**RE: State Significant Development SSD 17\_8699 – Greenwich Hospital, 97 – 115 River Road, Greenwich**

Please accept this as my submission for your consideration on the State Significant Development SSD 17\_8699 Staged Redevelopment of Greenwich Hospital (Concept Proposal) which is currently on public exhibition until 15 March 2019 by the New South Wales Department of Planning & Environment.

Comments on the Staged Redevelopment of Greenwich Hospital (Concept Proposal) as exhibited by NSW Department of Planning & Environment:

MARK-UP OF S04/T3 TO SHOW ERRORS/OMISSIONS

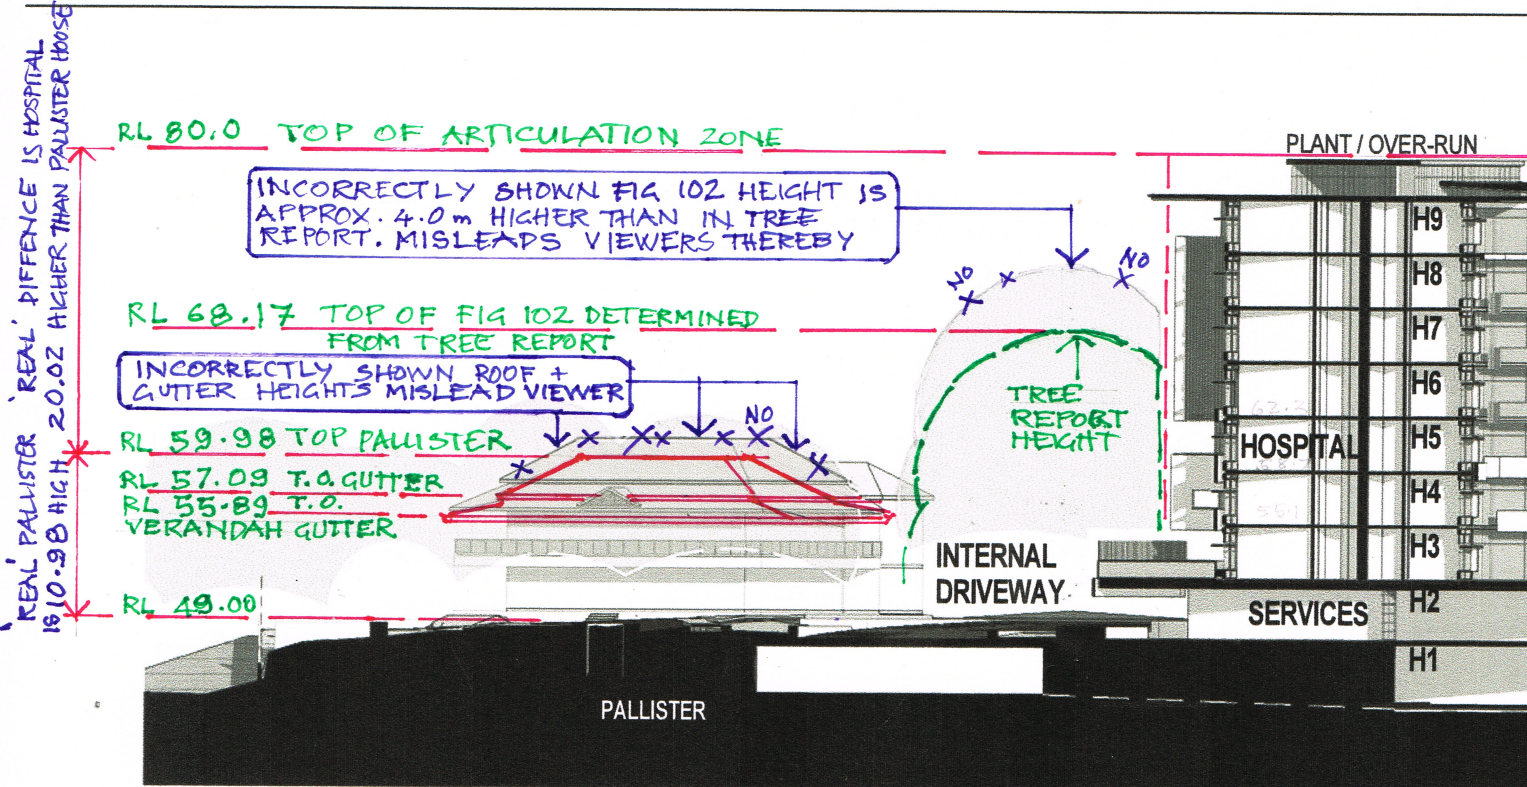
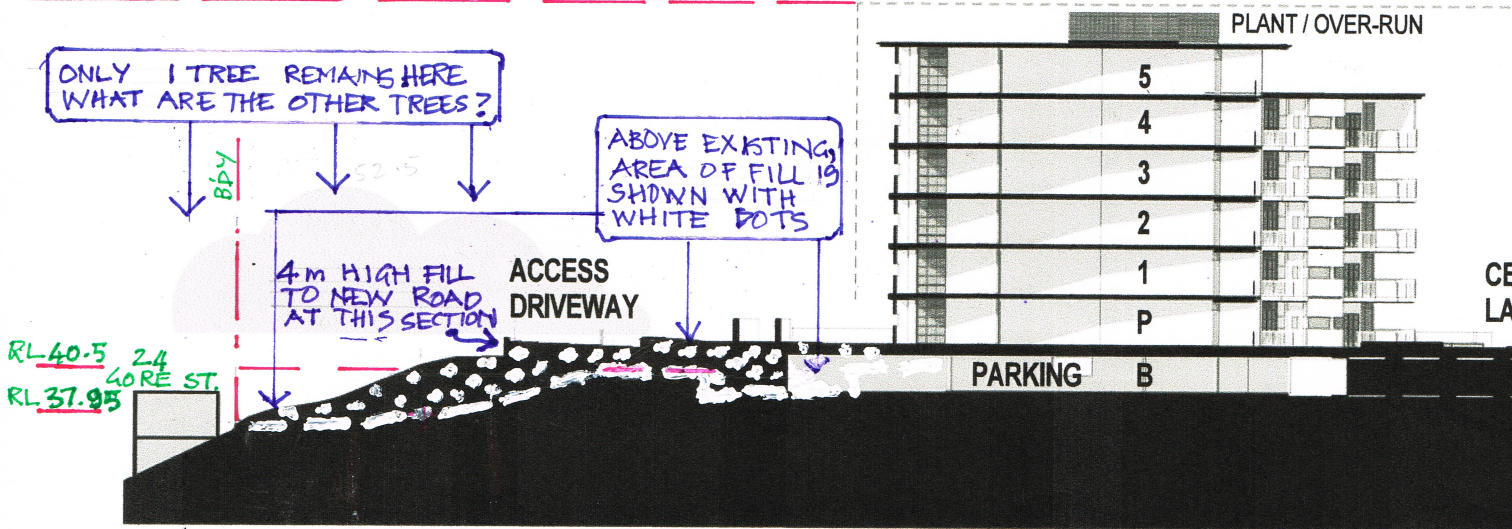
- The building heights for the Seniors Living Apartment buildings to be located to the west of the site, are excessive and will have a detrimental impact to the surrounding area.

- The houses to the west of the site will be dwarfed by the seniors living apartment building height.

- Figure 16 of the EIS does not accurately demonstrate how the bulk and scale of the proposed Seniors Living Apartment buildings fits with the houses to the west.
- The photomontage pictures provided in Appendix B1 Architectural Plans are strategic and do not accurately illustrate the impact of the bulk and scale of the proposal along River Road to the north west of the site. They are taken before a crest in River Road to distort the impact.
